RE: NOTICE OF EXHIBITION – SSD 7445 MOD 1, Site 9 SYDNEY OLYMPIC PARK

SOPA has reviewed the submitted modification request and wishes to raise the following matters in relation to the proposed development:

Relocation of the Substation Kiosk

General Arrangement Plan
Ground

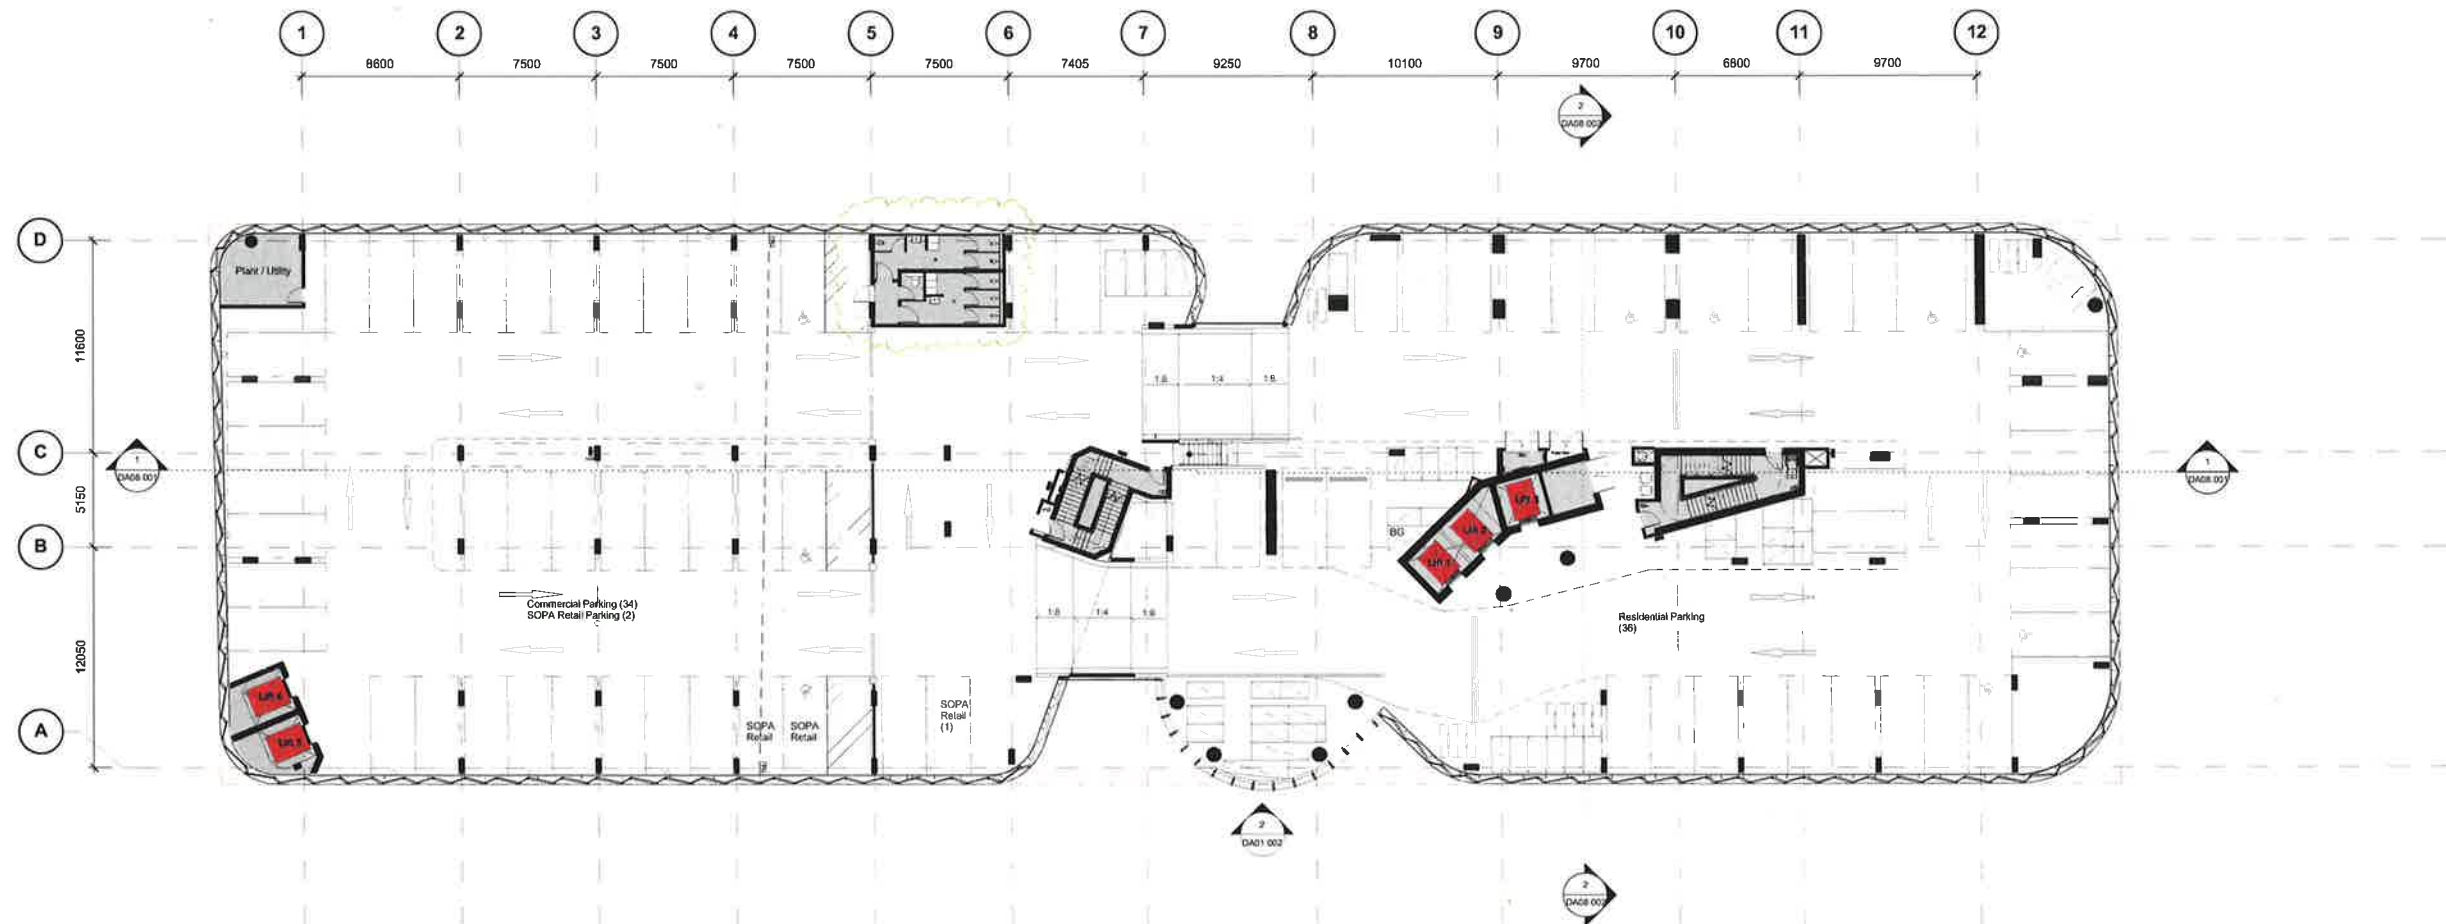
The modification request seeks to relocate the substation kiosks from the basement to SOPA land immediately to the western side of P3 car park. SOPA has no objections in principal to the relocation of the substation kiosk; however, as the kiosks will now be in a publicly visible location, they should be appropriately screened to minimise any adverse impacts on visual amenity. The location of the kiosks also must not obstruct pedestrian movement between P3 car park and the through-site link.

All electricity substation kiosks must be located in accordance with Ausgrid's requirements.

Prior to the issue of the relevant Construction Certificate, plans indicating the location and proposed screening treatments for the substation kiosks to the west of P3 car park must be approved by SOPA's Director – Environment and Planning.

Details of compliance must be shown on the Construction Certificate plans.
